IP Ref Number [REDACTED]

I would like to add to comments made on my initial representation concerning BMV

- KEY**
- Grade 1
 - Grade 2
 - Subgrade 3a
 - Subgrade 3b
 - Grade 4
 - Grade 5
 - Non-agricultural
 - Not surveyed

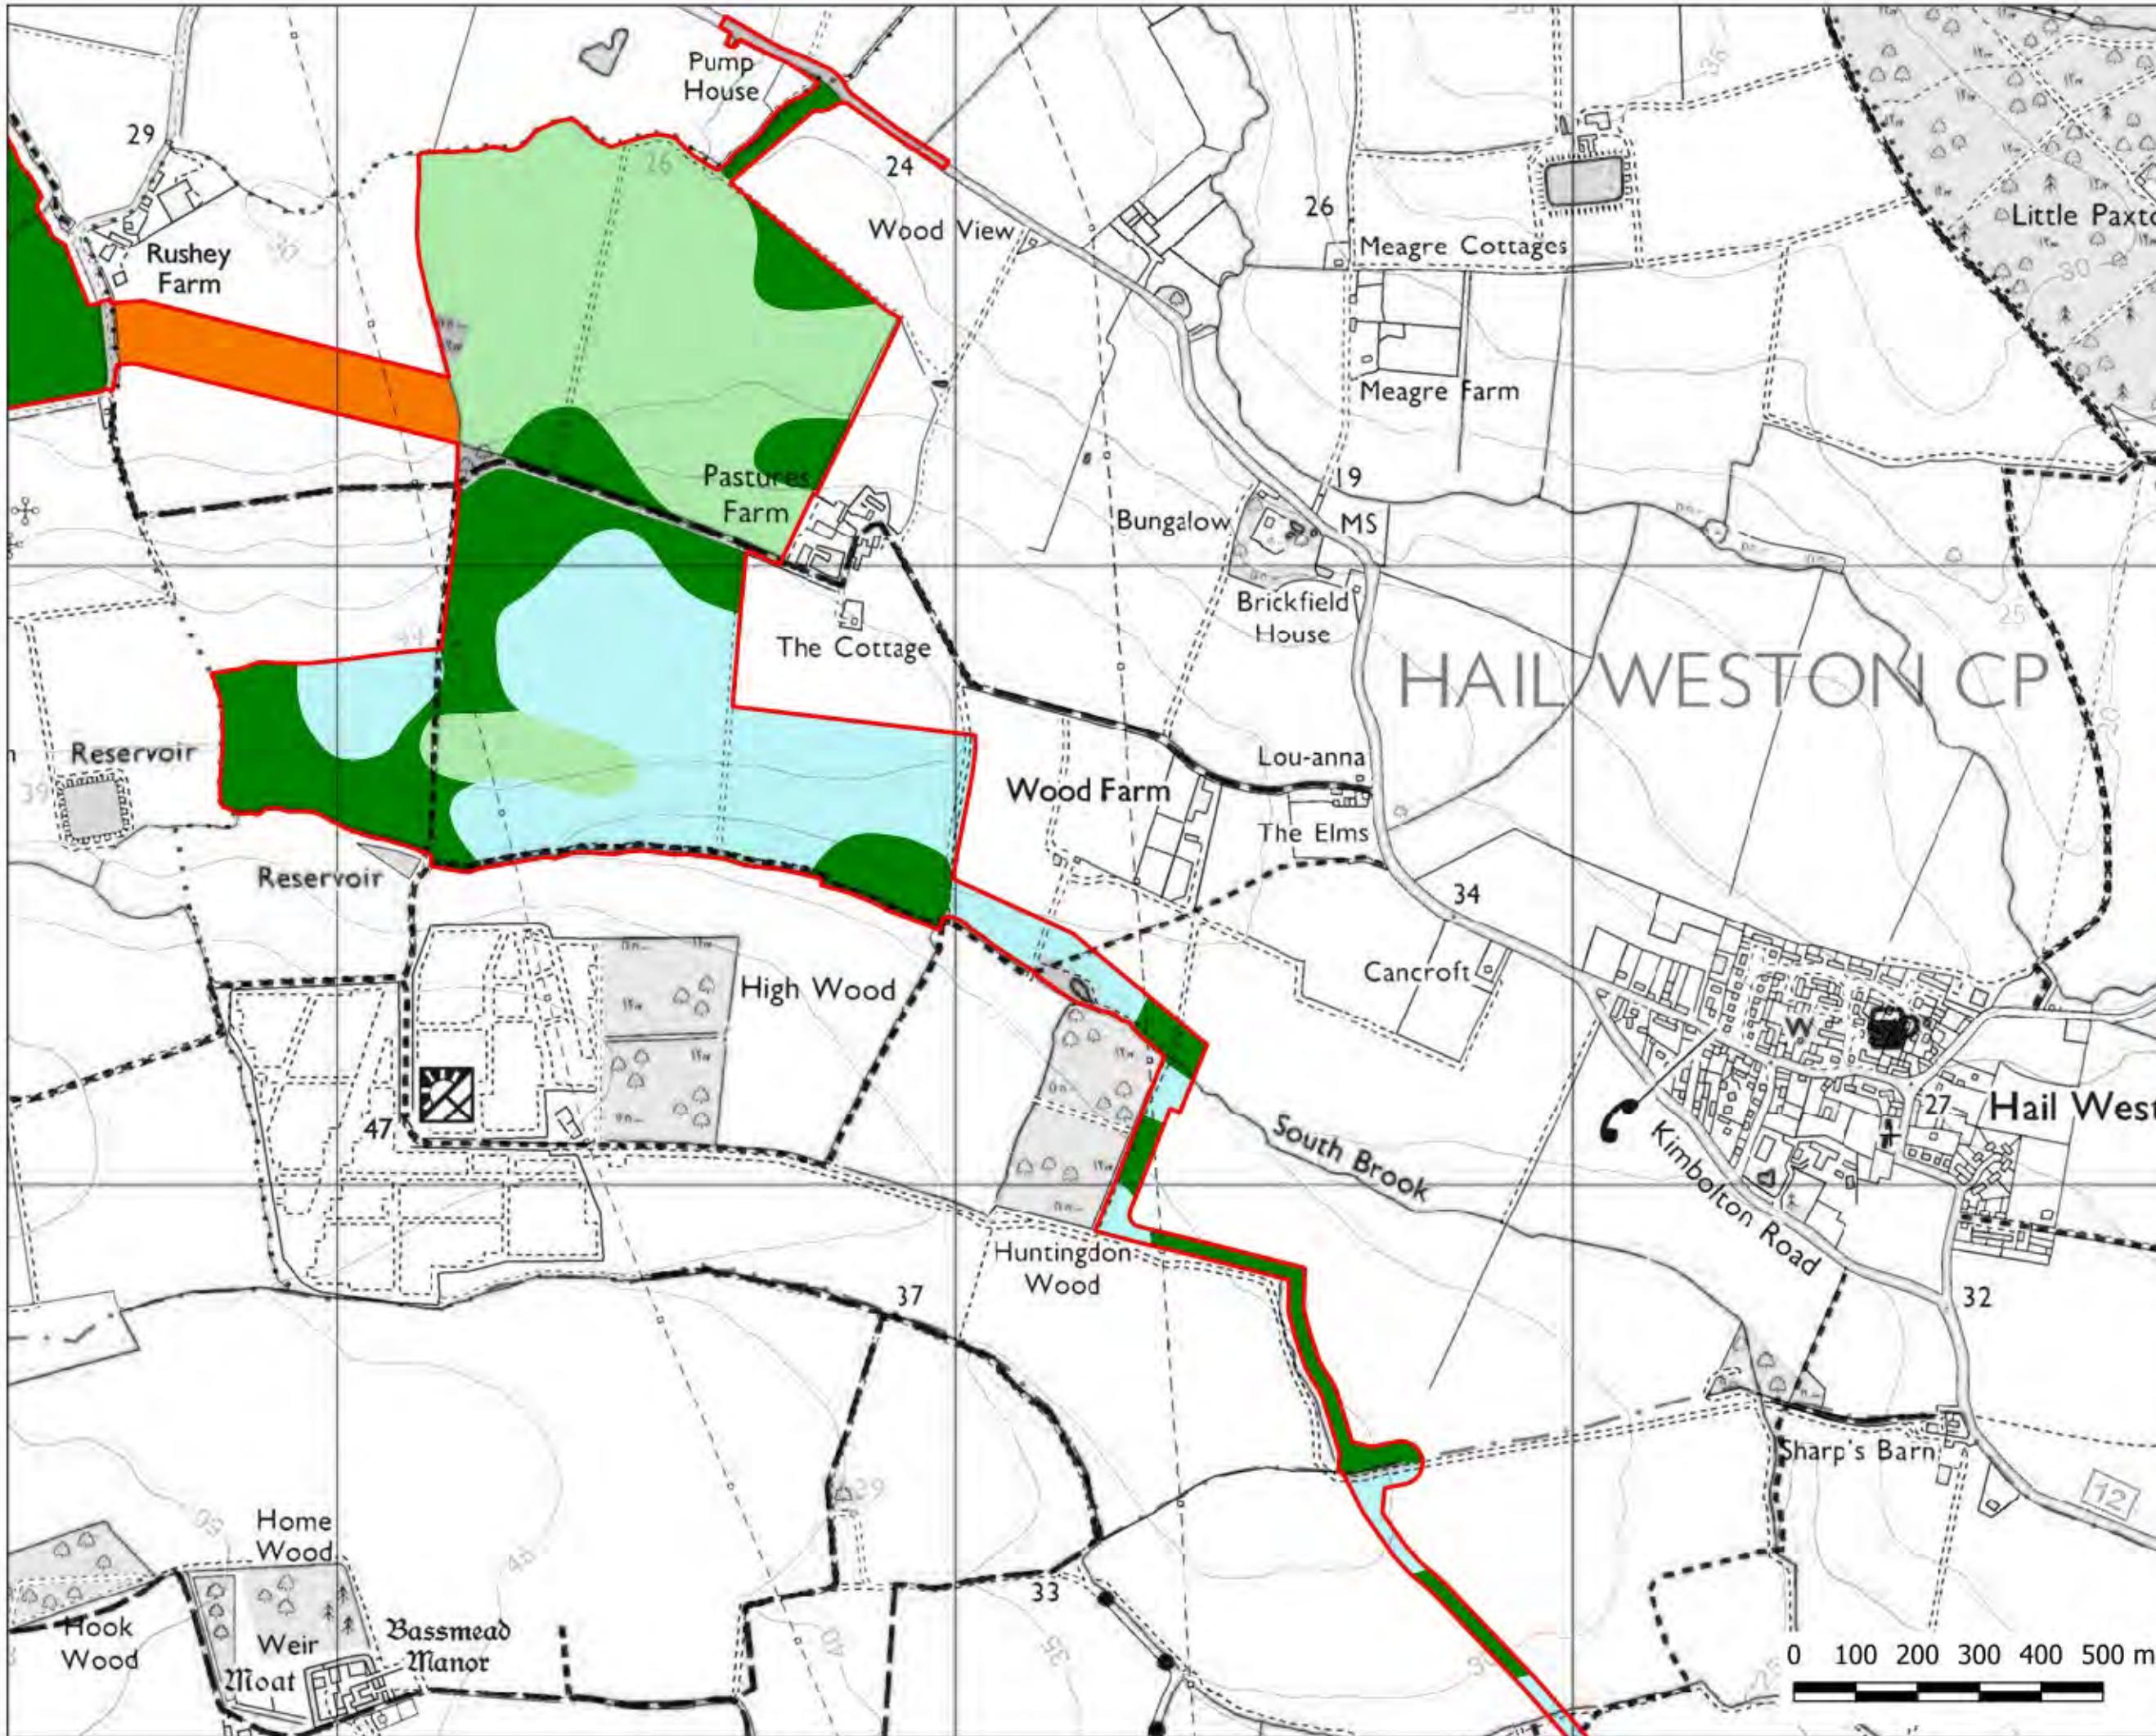
The level of BMV is critical to the planning application as government guidelines state that development should be avoided on these areas. In AP-049 Tables 13.8 /13.9 and 13.10 the applicant provides a summary of the land quality of the solar farm, as assessed by sampling, in comparison to the surrounding areas. Their conclusion is that the site is in "a part of the local area that is of comparatively lower agricultural value". For this conclusion they use provisional map data which they state "are not sufficiently accurate for use in assessment of individual fields or on development sites". Examination of the provisional maps for the site gives a value of Class 2 land as higher than 40%, much closer to the local average. In terms of yield, which can also be used to classify land, the applicant's average assessment of 8 tonnes per hectare would give a soil class of 3a.

During the assessment of BMV area the applicant includes non-agricultural land i.e. buildings, roads and trees of 4.6%(EPE). As these are areas not available for agriculture or panels, they should not be included in the BMV calculation. Removal would raise the level of BMV for the site.
